Emailed December 31, 2020
DRB Comments for Meeting on 1/6/2021

From: Nicole M. Friedt, P.E., Development Review Engineer
AMAFCA

RE: DRB COMMENTS for PR-2020-004708

3-C REPLAT LOT 3 INTERSTATE INDUSTRIAL TRACT UNIT II
(Explore Academy):

SHEET NO.
SDP1.1
OF

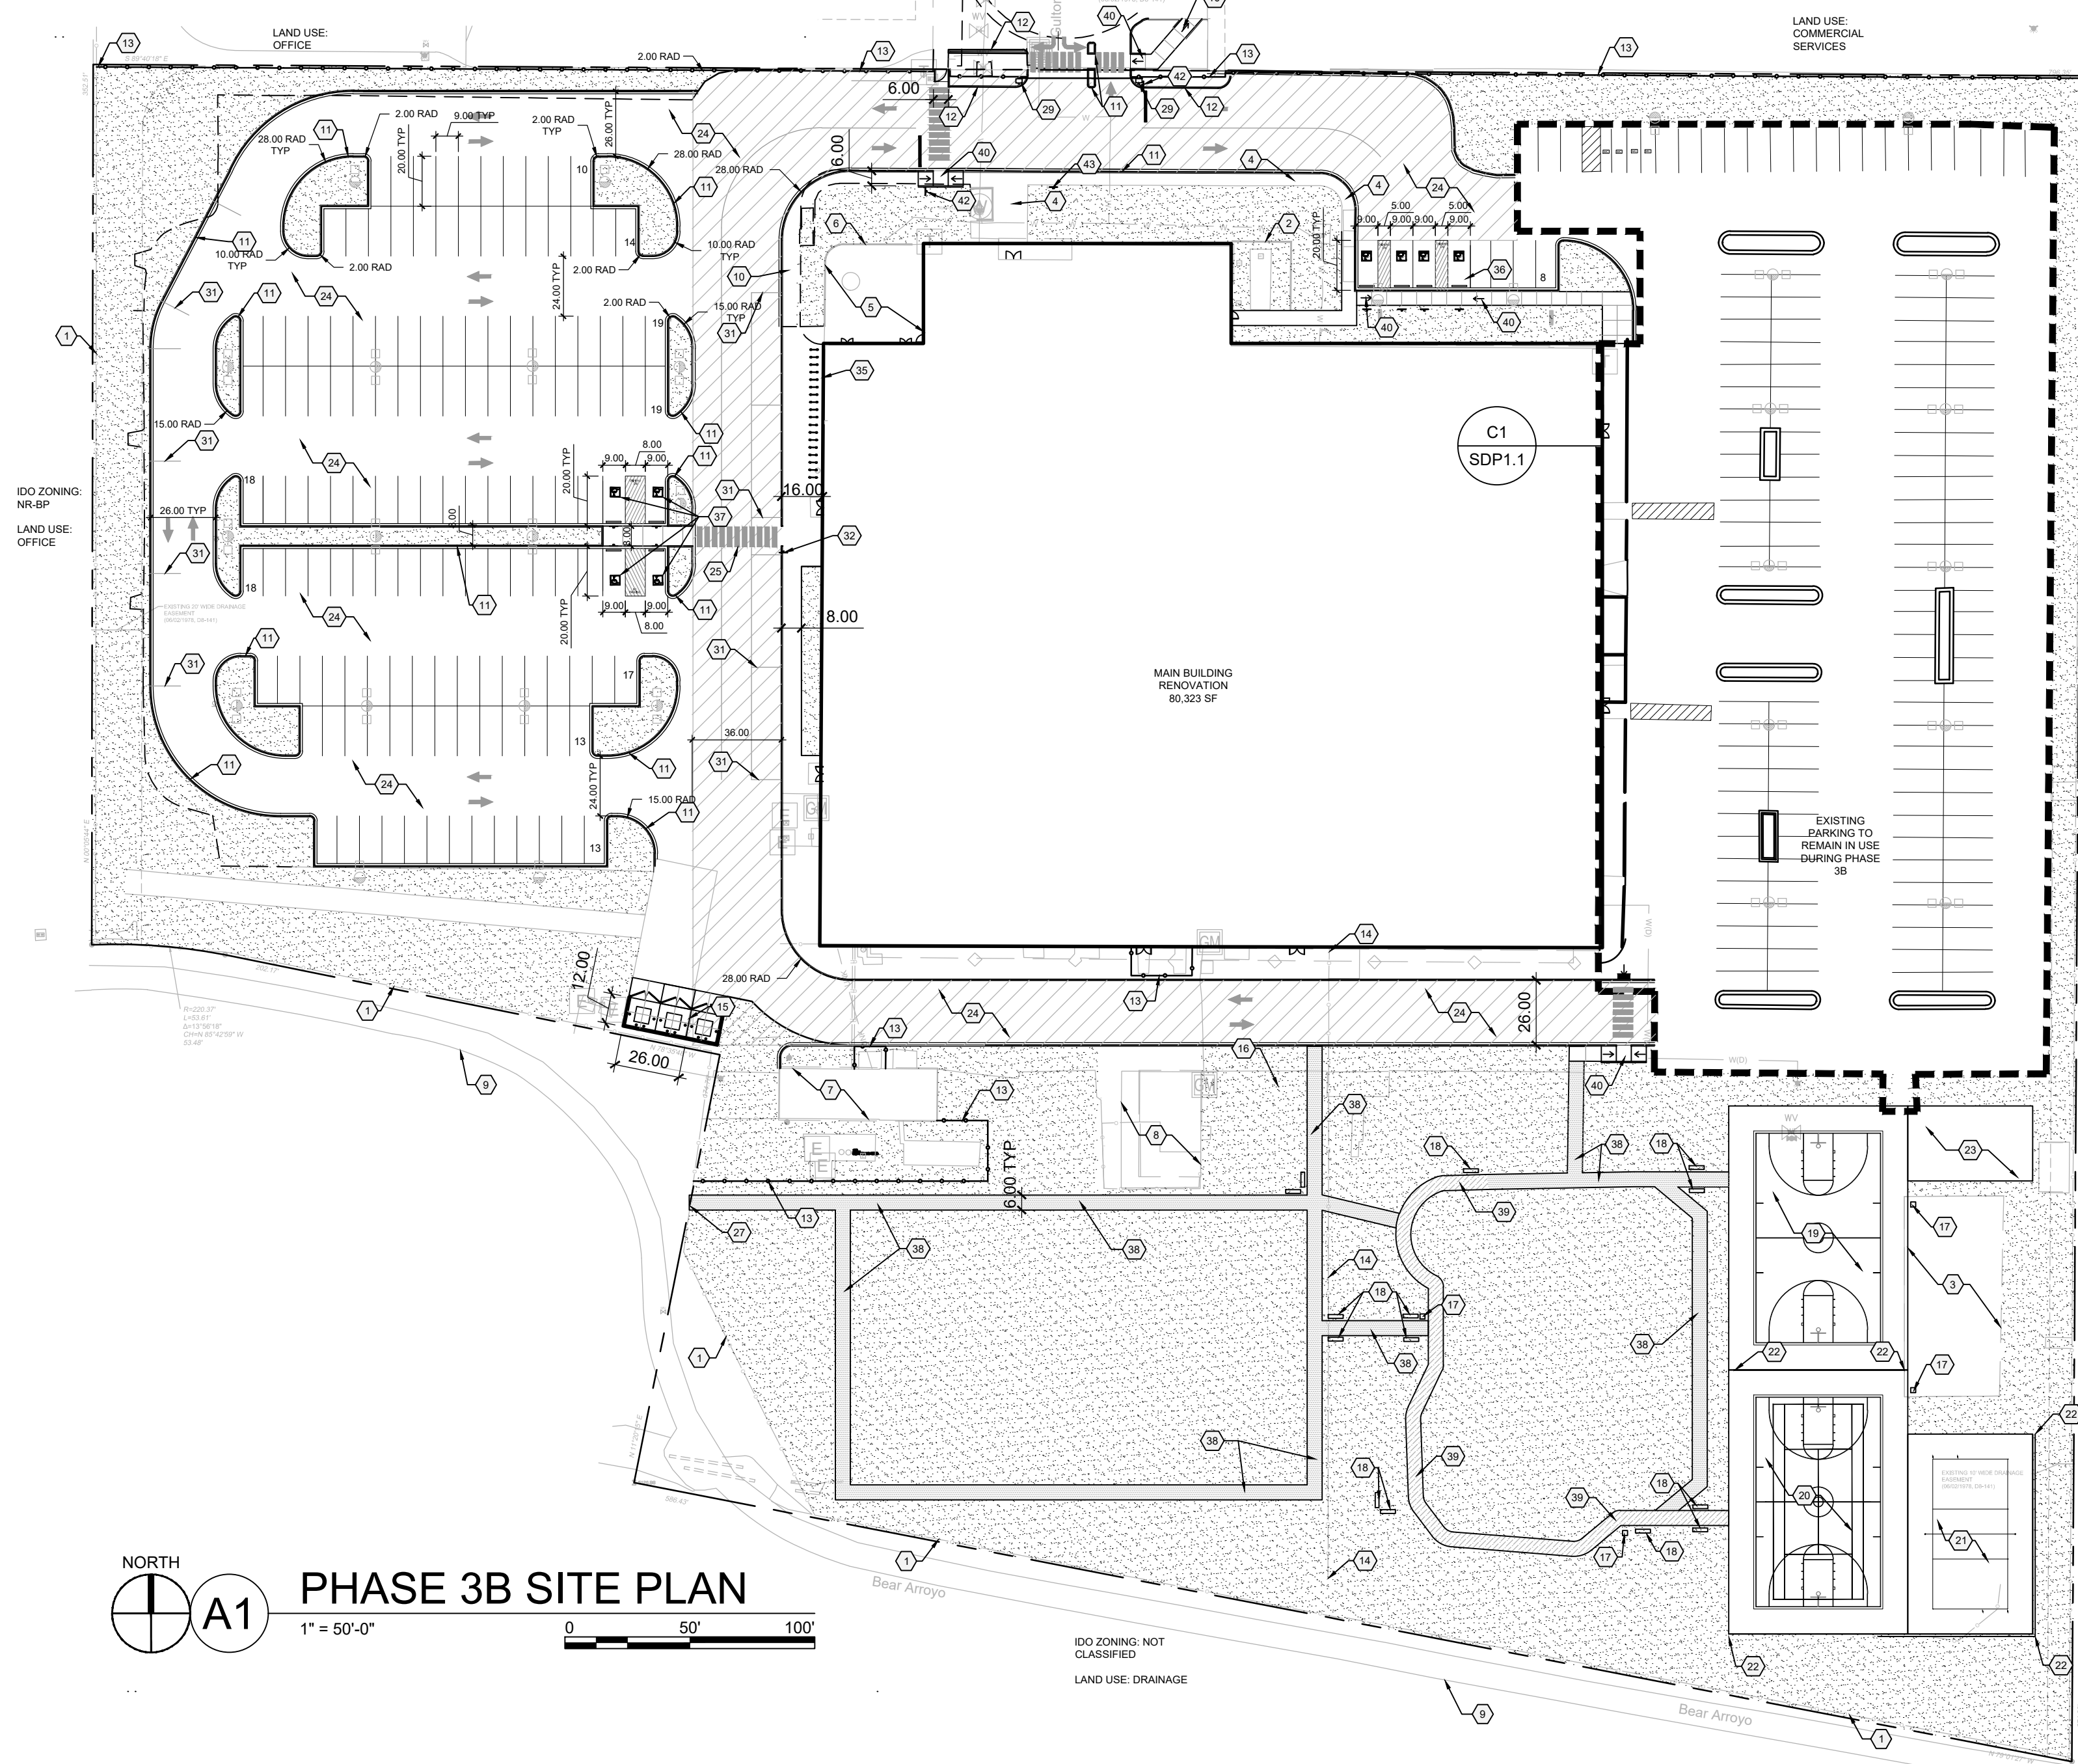
- Please ensure that a maintenance access easement to AMAFCA and/or COA exists or is provided for the Bear Canyon Arroyo Trail where it crosses into the proposed property site.
